NJA Ref: 21/232

27 September 2021

LPA Ref: FG/90/21/HH
Proposal: Erection of addition of second floor, part single, part two storey extension and wrap around terrace
Site: 1 Sea Drive, Ferring, BN12 5HD

Project: Extension & Refurbishment	
for Chris Levett	
at 1 Sea Drive Ferring Worthing BN12 5HD	
Contact: Michael Austin R/BA	
E-mail: project@austinlebbon.co.uk	
Web: www.austinlebbon.co.uk	
Phone: 07958427610	
Dwg Ref: 2048 [PL] 05	Rev: A Date: September 2021

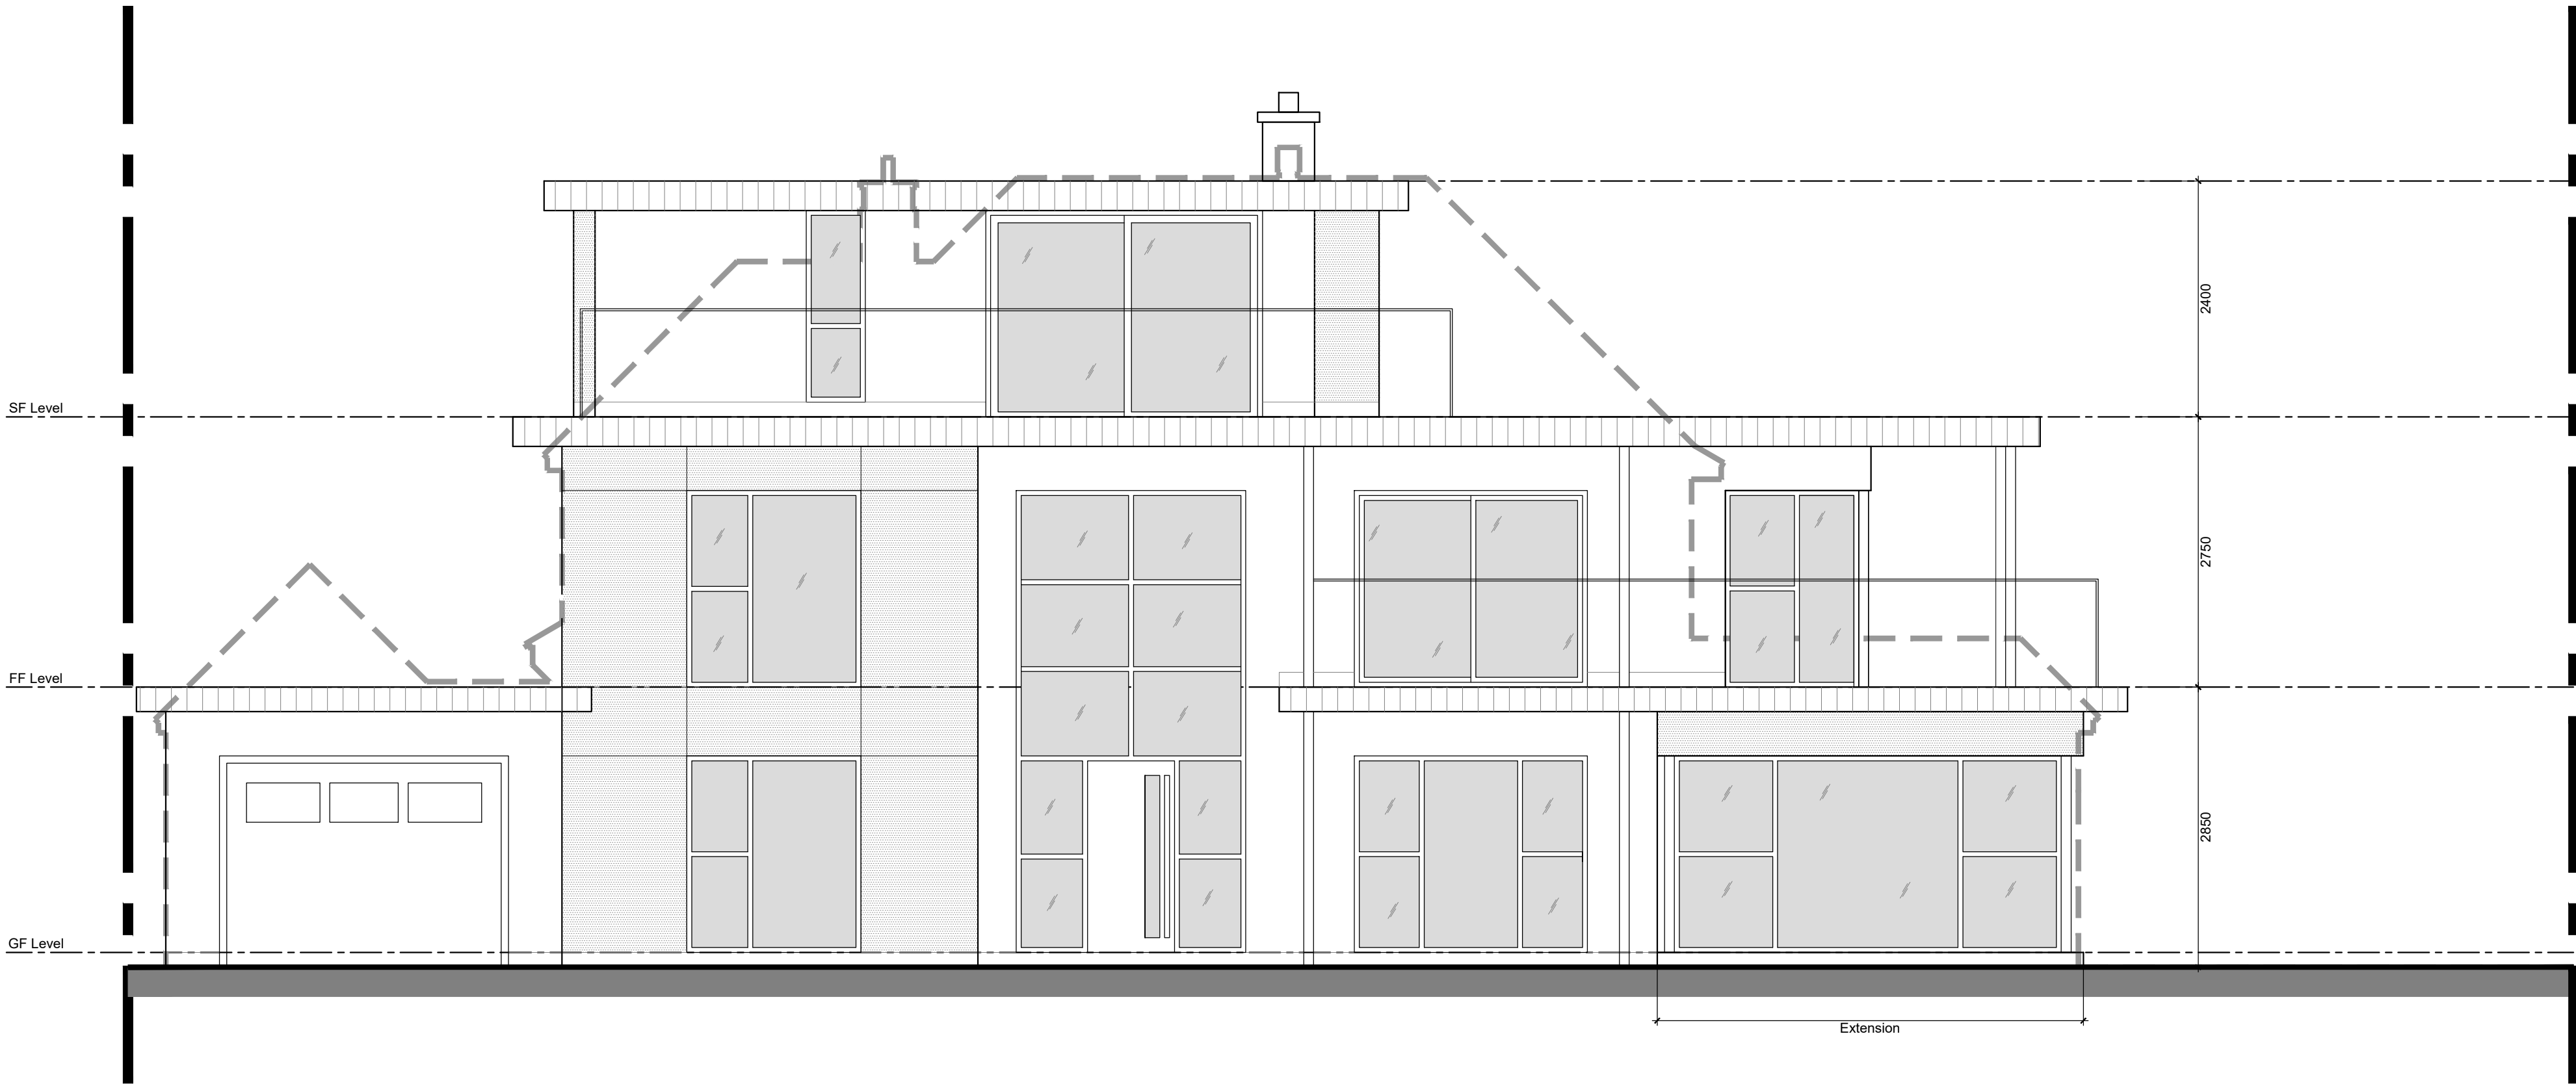
In respect of the proposed plans, the floor plans and elevations (PL01, PL02 Rev A, PL 03 Rev A and PL04, PL05 Rev A) show the garage to number 1 to be offset from the common boundary however, this conflicts with the Proposed Street Scene (PL 010 rev A) and Proposed Site Plan (PL 001 Rev A) which show the garage to be situated right up to/on the boundary.

The proposed first floor contains one north facing bedroom window and the proposed second floor contains two north facing bedroom windows and a landing window. These windows would overlook the private rear garden area of number 3 Sea Drive, causing considerable overlooking and loss of privacy. At present, due to the chalet style design of number 1, the only windows to the rear elevation of the dwelling at first floor level are three small windows set into the roof slope. However, the proposal in stark contrast includes the insertion of a large number of ground, first and second floor windows and doors to all elevations. The number, siting and full length design of the windows and doors particularly to the north facing elevation would appear excessive and would cause substantial and harmful loss of privacy to my clients including serious harm to the peaceful enjoyment of their garden. The combined appearance of these windows would create an oppressive feel and the level of overlooking would be detrimental to privacy and wholly unacceptable.

The impact of the proposed terrace to the top (second) floor will also cause considerable, and unacceptable overlooking of 3 Sea Drive. The proposed second floor sits to the western side of the dwelling, which is the most sensitive location of the property in term of neighbouring amenity, sitting unacceptably close to number 3.

The plans indicate that a clear glass screen will be installed to the top second floor terrace providing no protection from overlooking. However, even with a screen this terrace would, due to its height and proximity to the western boundary, cause considerable loss of privacy to number 3 and will appear overbearing and oppressive looking down upon the private south facing terrace and garden area. Furthermore, the proposed second floor terrace will not only harmfully overlook number 3 but it also will potentially cause harmful noise and disturbance so close to the shared boundary.

Project: Extension & Refurbishment	
for Chris Levett	
at 1 Sea Drive Ferring Worthing BN12 5HD	
Contact: Michael Austin R/BA E-mail: project@austinglebbon.co.uk Web: www.austinglebbon.co.uk Phone: 07958427610	
Dwg Ref: 2048 [PL] 06	Rev: A Date: September 2021

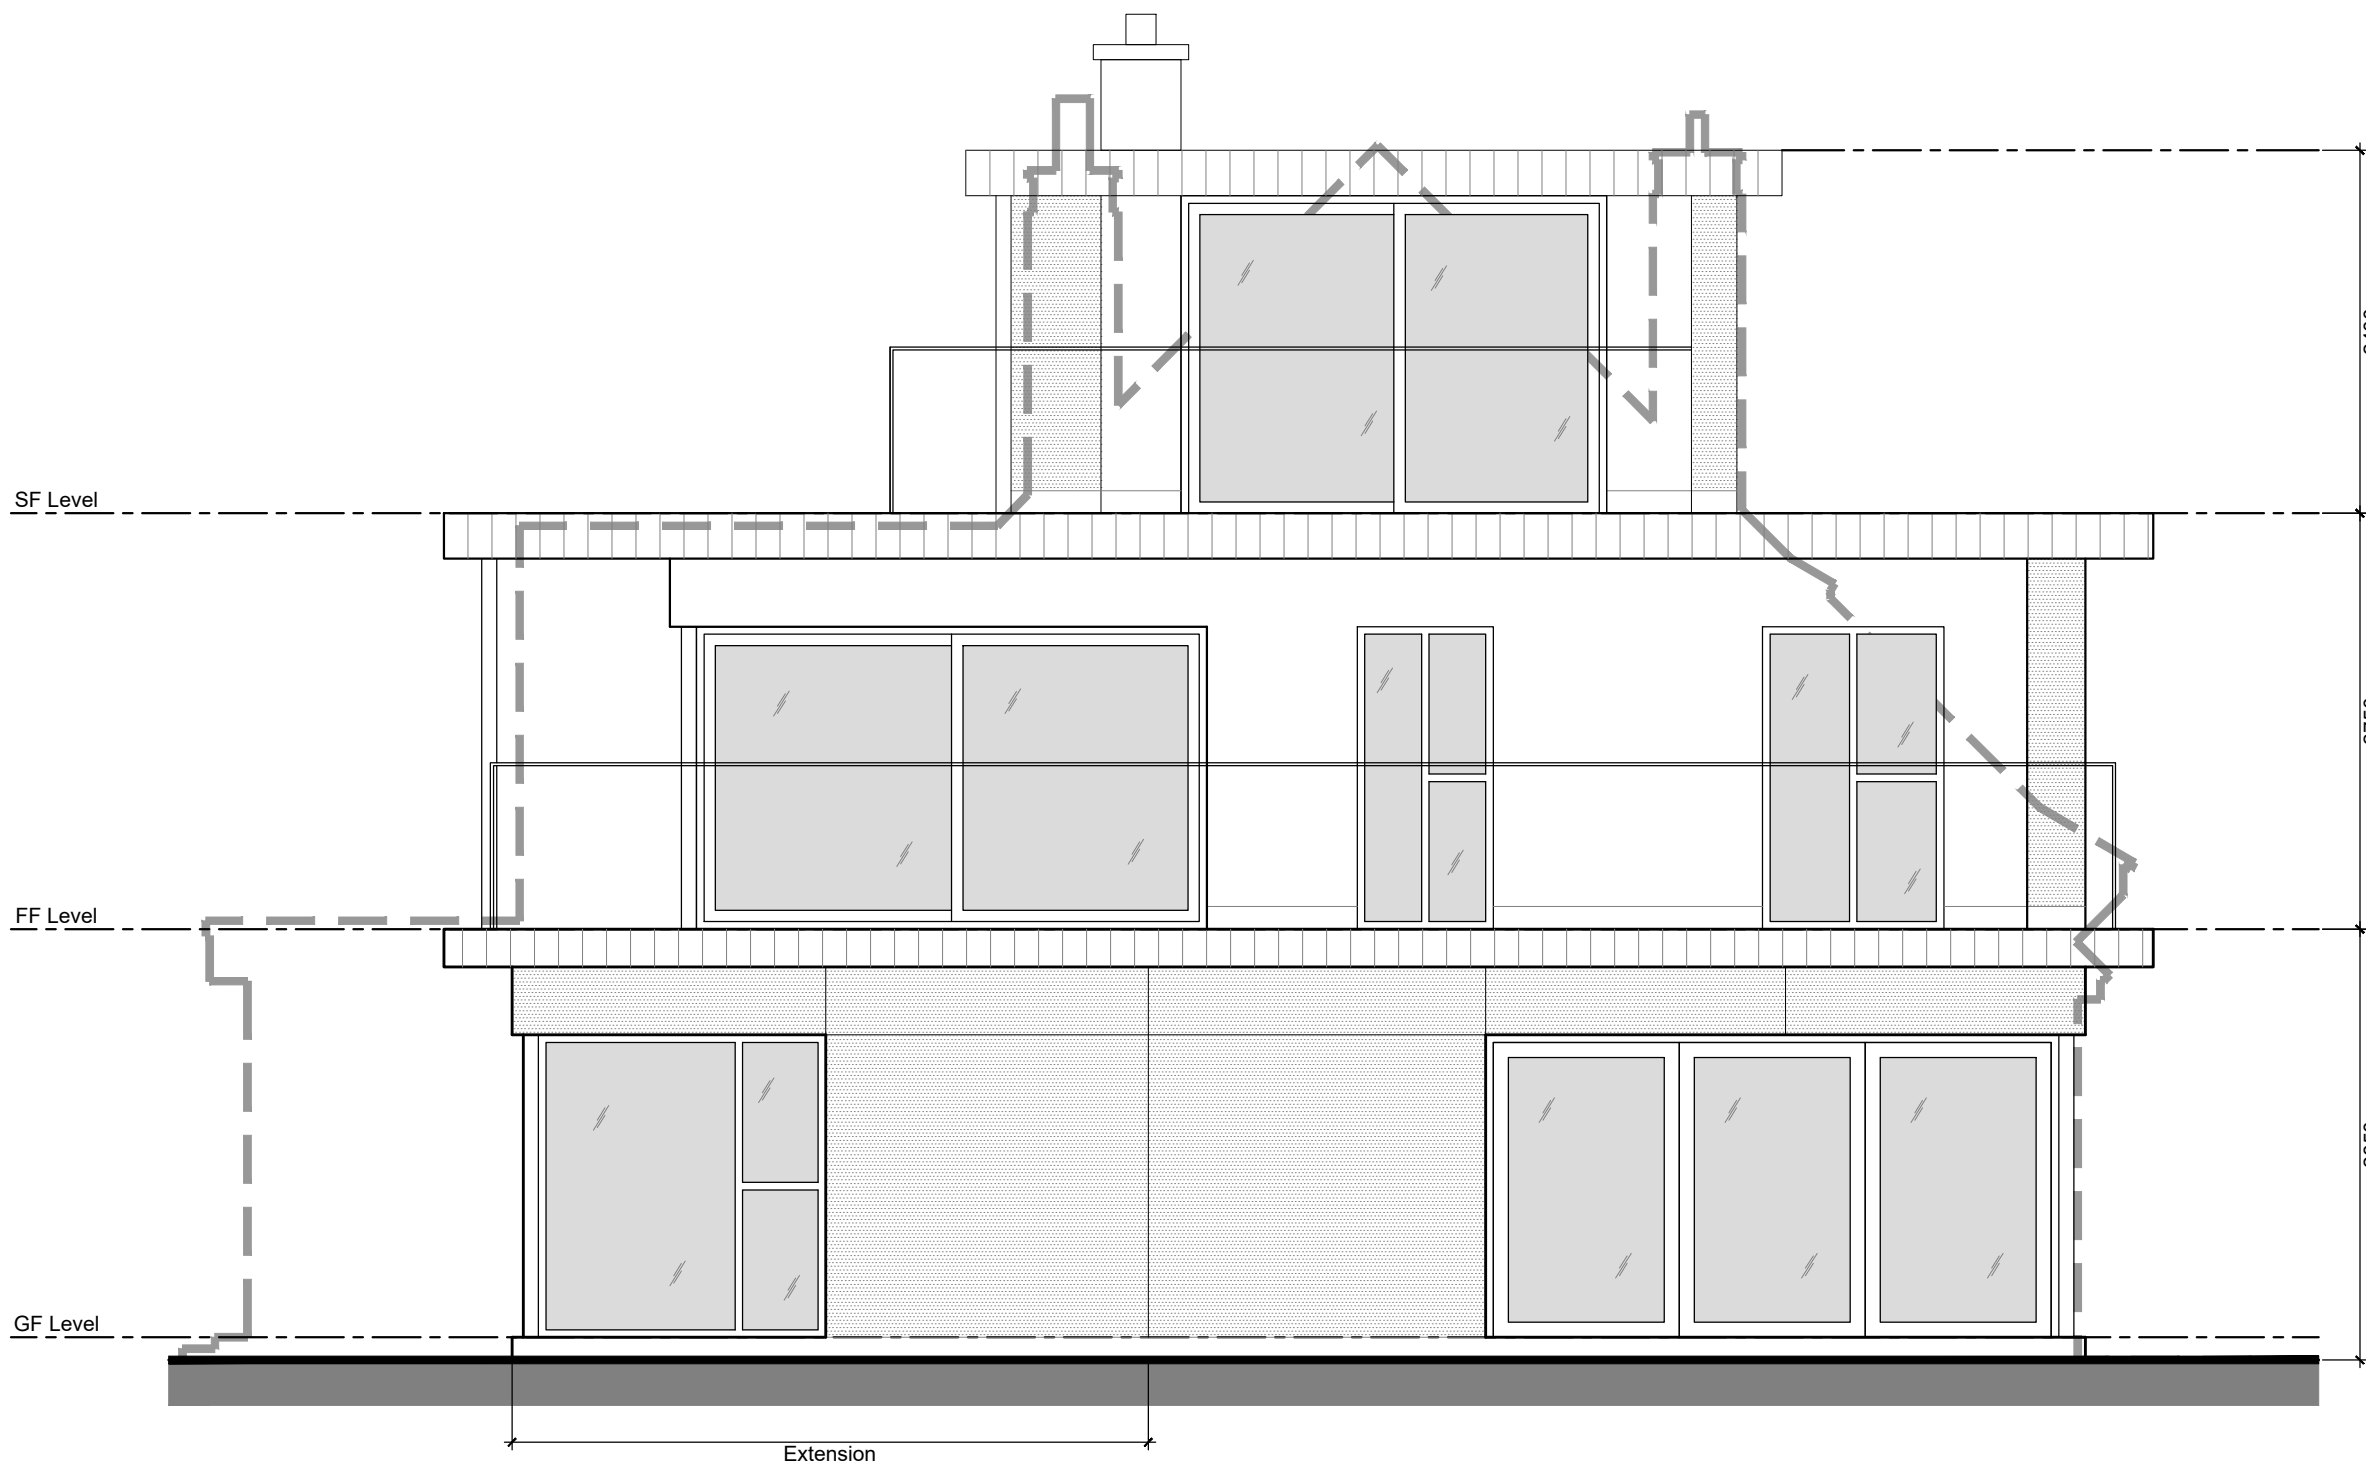
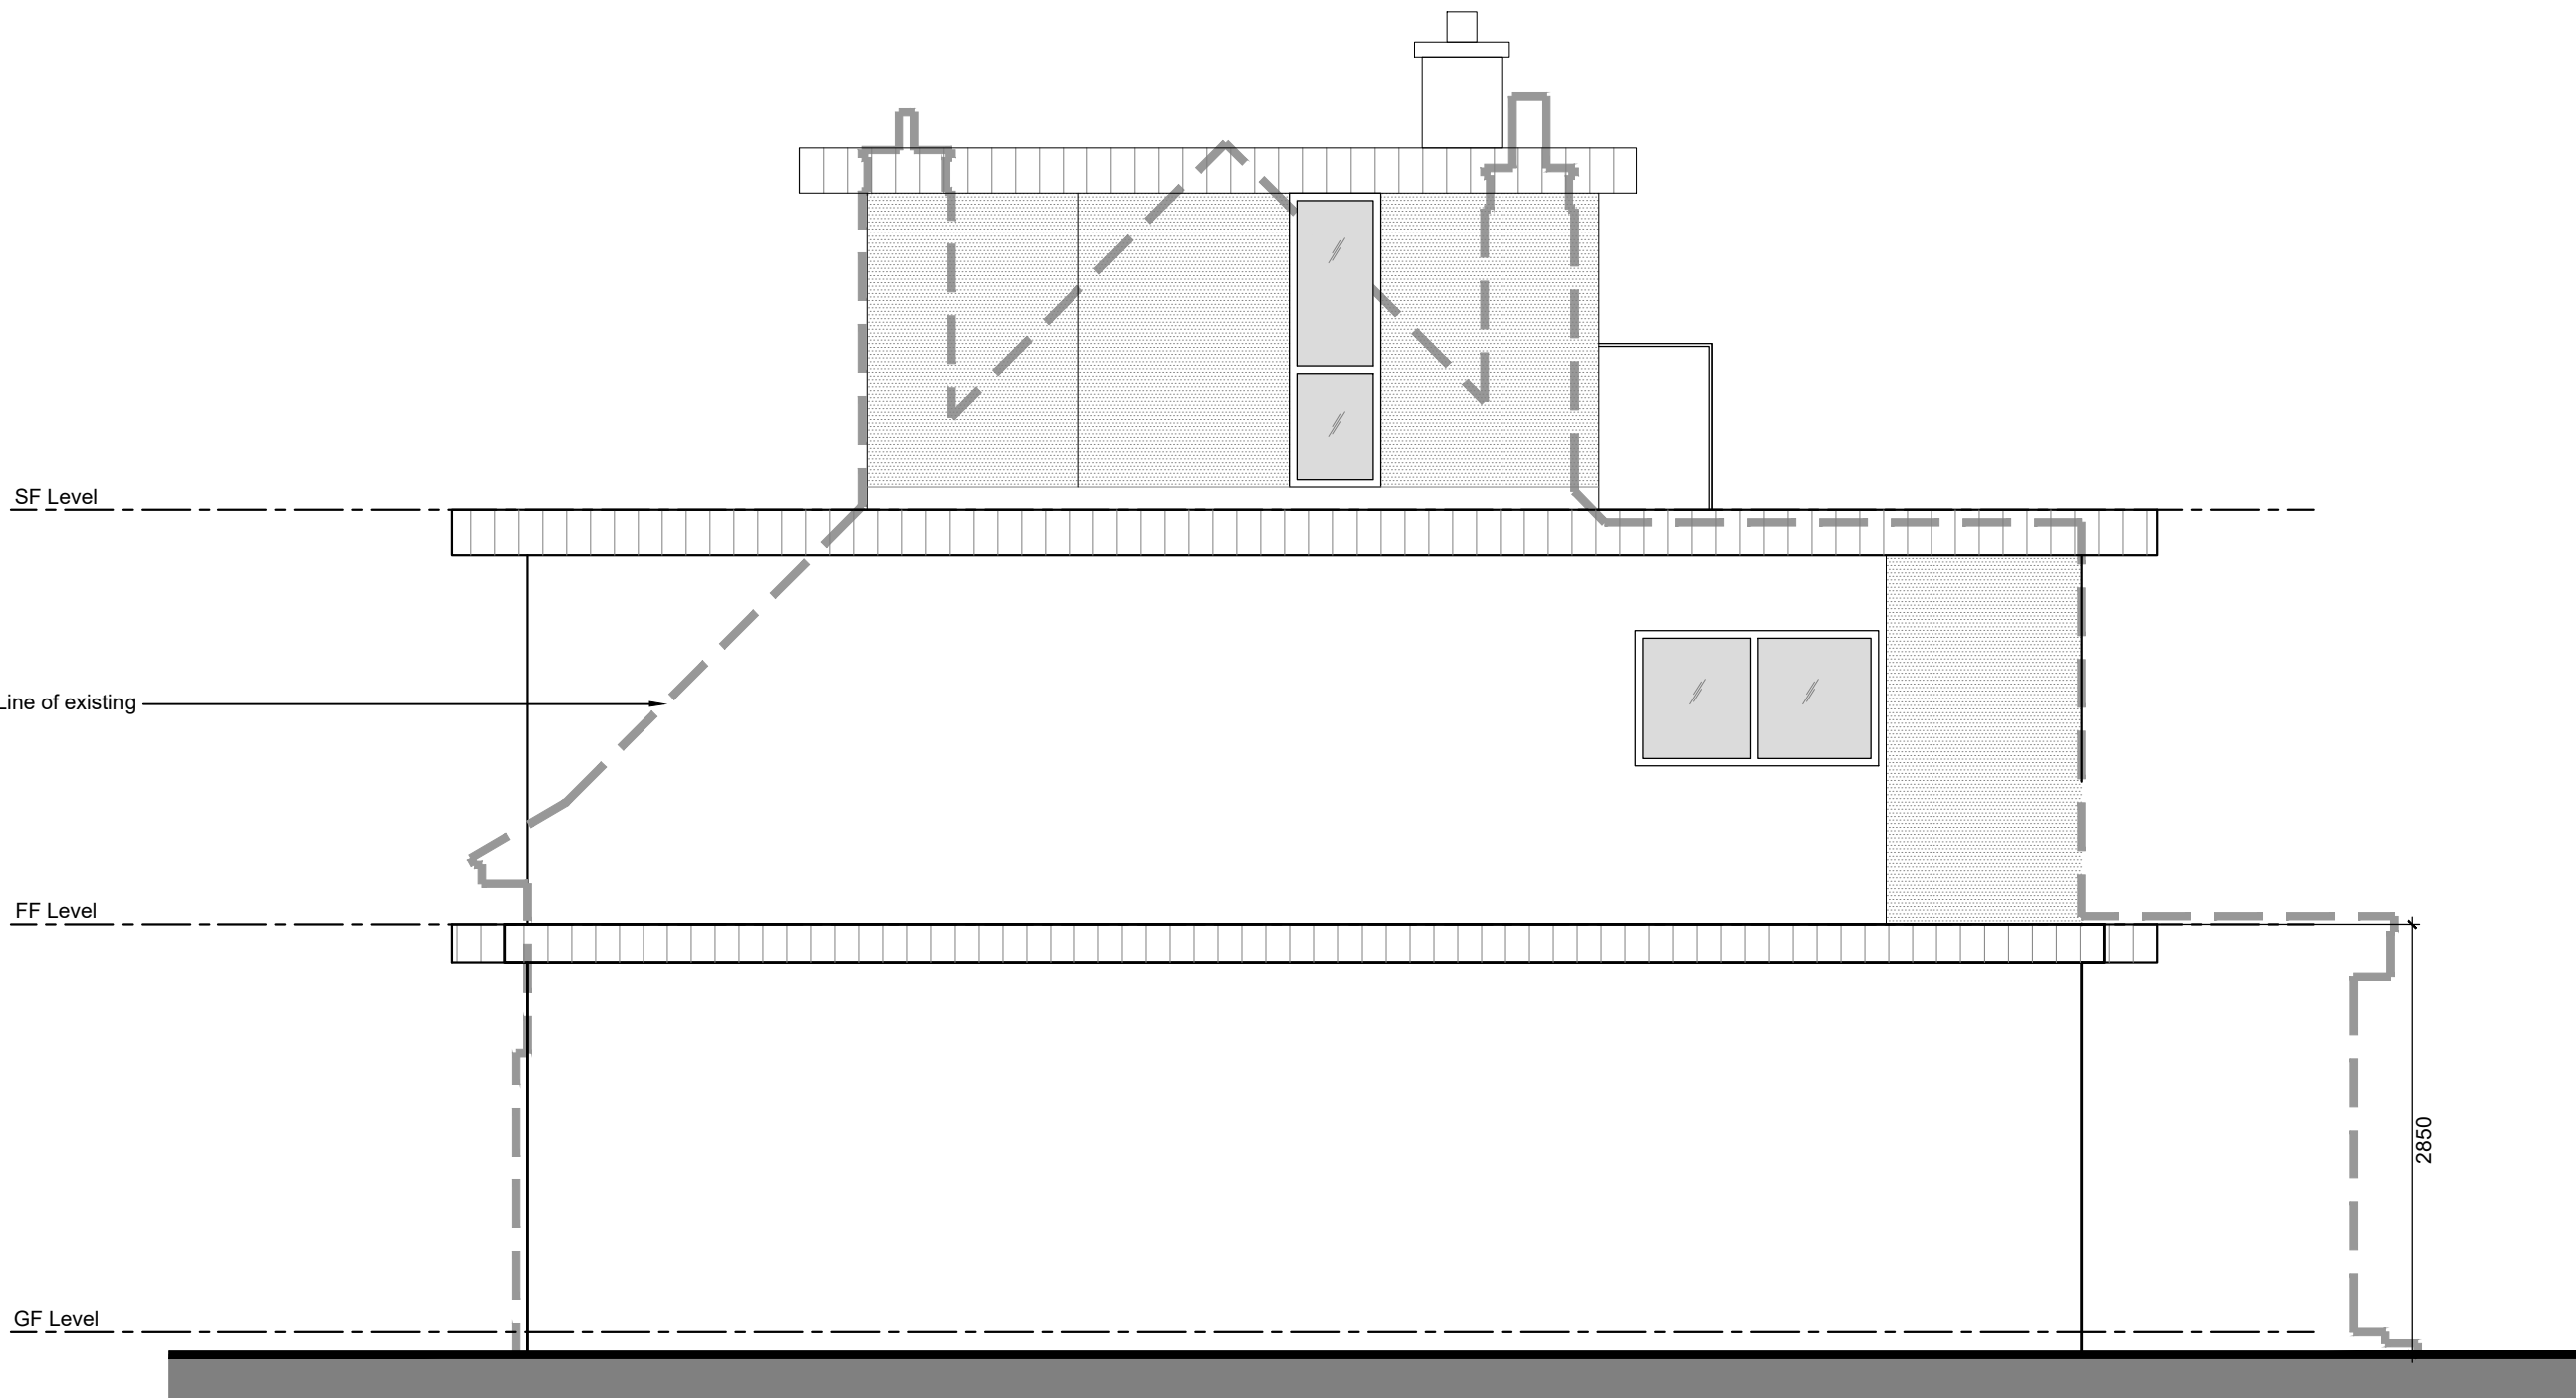
In terms of other window positions, my clients still remain concerned about the windows to the west facing elevation of number 1 comprising a bedroom window at first floor level and a staircase window at second floor level. The staircase window is high up and due to the front to back roof slope design of number 3, this window would afford views over and down into my clients' rear garden area which is unacceptable. The bedroom window (serving bedroom '3') is a secondary window and given that this room also has a main, south facing window, the side window is somewhat superfluous and is insensitively sited in relation to number 3.

At present, there is only one first floor dormer window to the west elevation of number 1 which is a later addition, set into the roof slope away from the boundary and which is fitted with obscure glass (as required by condition). Therefore, the existing situation to this elevation would be substantially altered through the creation of new windows and a second floor terrace that would be detrimental to the residential amenity of number 3. My clients ask that the new windows to the west elevation are eliminated from the proposal. The bedroom window is not necessary and the second floor stair case window should at the very least be fitted with obscure glass (and non-opening) to reflect the existing situation.
